**From:** [REDACTED]  
**To:** [Cleve Hill Solar Park](#)  
**Cc:** [REDACTED]  
**Subject:** Cleve Hill Solar Park Project EN0085 re 20018862  
**Date:** 12 June 2019 07:49:56  
**Attachments:** [REDACTED]

## Cleve Hill Solar Park – Soil and agricultural Use Classification– Objections

Cleve Hill Solar Park development engaged Land Research Associates Ltd to conduct a Soil and Agricultural Use and Quality survey at Cleve Hill Farm near Faversham, Kent, the land being proposed as the site for a solar farm development. The report 1294/1 was dated 22<sup>nd</sup> March 2017 (presented in Appendix II) and on-site field work was conducted either in the first or second week March 2017 (which is based on the laboratory report prepared by NRM and sample receipt dated 13/03/2017, presented in Appendix III).

Date: 22/03/2017

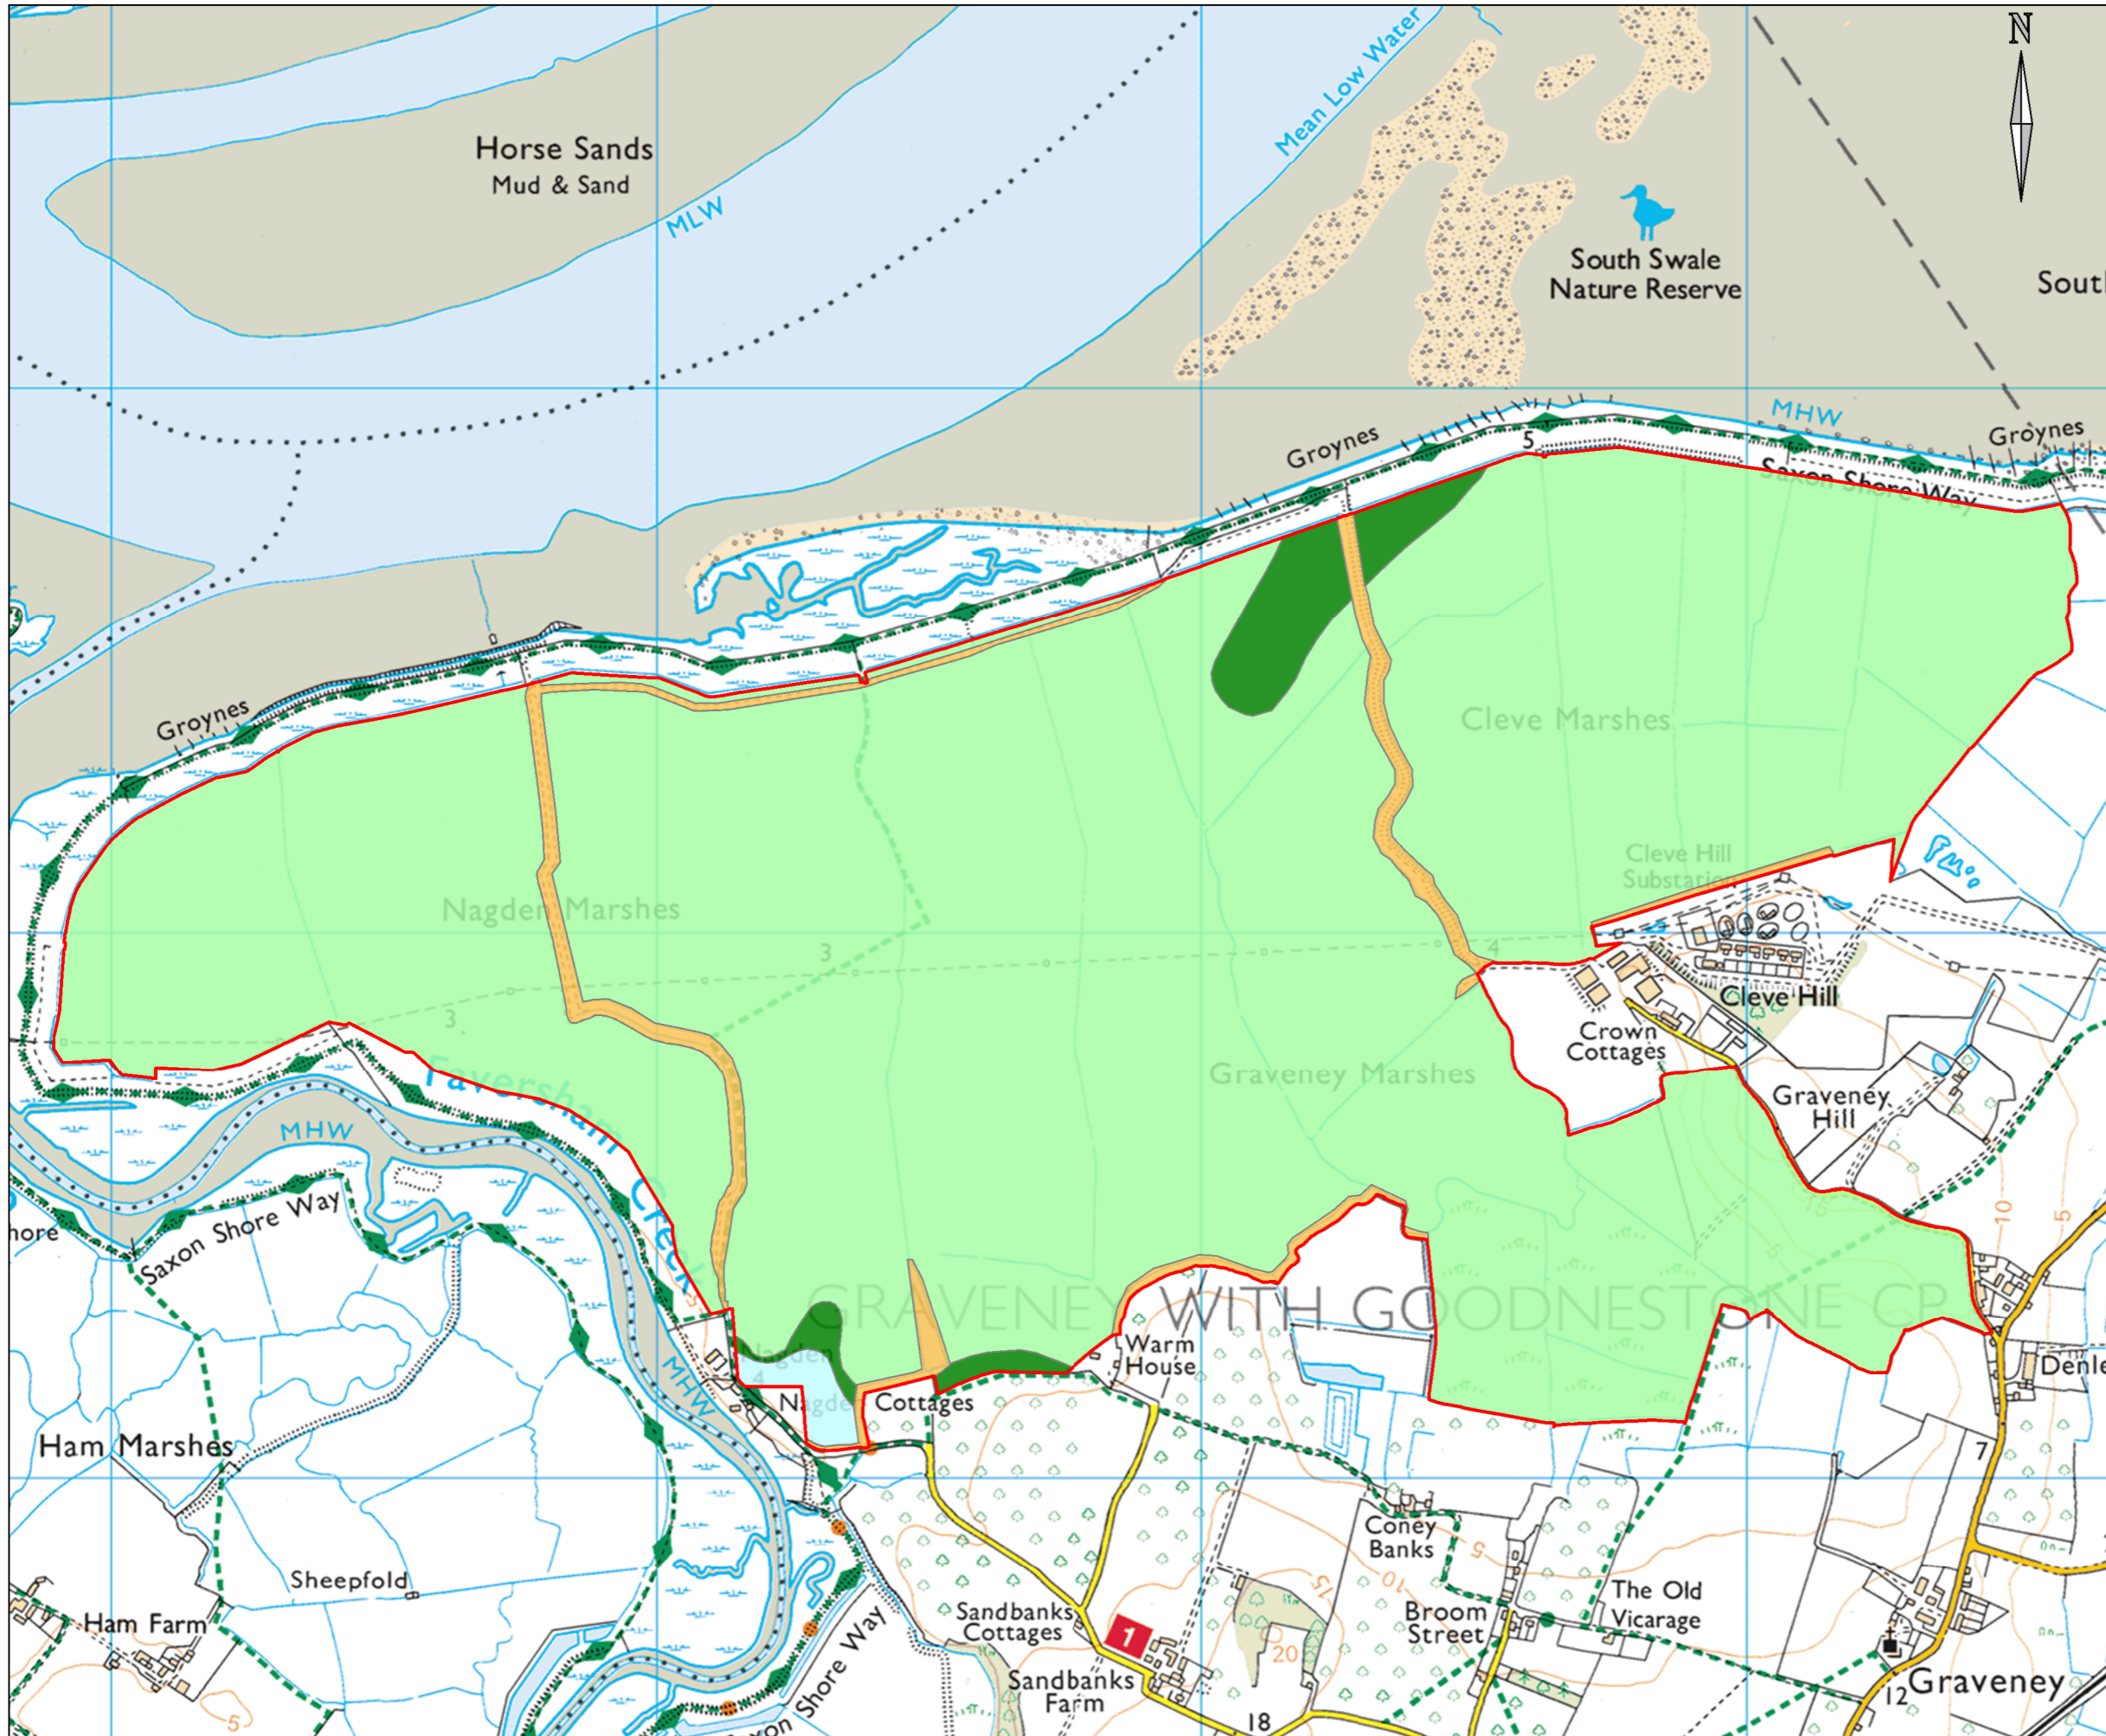
- There are 23 field observations missing within the report for field observation points 123 to 156 and no reason given why this data has been omitted;
- No data is presented for field observation points 27, 67 and 157. Again no explanation was provided why this data has been omitted;
- There are typographical errors in the drawing representing the observation point locations, with number 147 presented twice, and observation point 148 appearing in the incorrect sequence and observation point 158 not presented in the drawing;
- No compass rose presenting North;
- The majority of the field observation points do not reach target depth of 120cm as detailed in the ALC MAFF 1988 guideline.

However, in the case of observation numbers 35, 37 and 54 these locations should be compared to Figure 8, as no gleying or mottling has been observed within the first 40cm. These three sample locations, comprising approximately 6 ha, were incorrectly graded in the Cleve Hill Solar Park SALUQ 2017 report, as the field observation should have been compared to Figure 8 of the MAFF 1988 guideline.

Furthermore, In the case of the observation point descriptions presented in the Cleve Hill Solar Park SALUQ 2017 report, and based on the local metrological data detailed above, the following additional observation points have been re-assessed considering a Wetness Class II, that the clay soils in case of 12, 20, 30, 46, 62, 73, 74, 78, 90, 91, 94, 103, 106, 107, 109, 110, 111, 112, 113, 114, 116, 119, 120, 121, 161, 162, 163, 165, 167, 170, 171, 173, 176, 177, 180, 184 and 185 are identified as Subgrade 3a soil based on the Field Capacity Days and soil texture of the top 25cm.

Additionally, the silty soils (abbreviated as SC) at observation locations 3, 4, 6, 9a, 10, 13, 14, 17, 20, 21, 22, 24, 28, 29, 31, 33, 40, 41, 42, 43, 44, 45, 47, 48, 57, 58, 60, 61, 63, 64, 72, 75, 76, 77, 79, 88, 89, 92, 93, 104, 105, 117, 118, 158, 159, 164, 166, 168, 169, 172, 174, 175, 179 and 108, can be classified as Subgrade 3a using the same approach detailed above.

Paragraph 3.9 of the Cleve Hill Solar Park SALUQ 2017 report details that 'in small areas in the south east around Cleve Hill, the land slopes at between 7 and 11 degrees' and that 'gradient is therefore an equally limiting factor on this land'. However, this statement is not corroborated with any data. Based on data presented in Appendix of the Cleve Hill Solar Park SALUQ 2017 report, details of observations at each sampling point, detailing 186 observation points, the steepest slopes reported were 6° at sample location 164, 5° at location 174 and 4° at location 180.
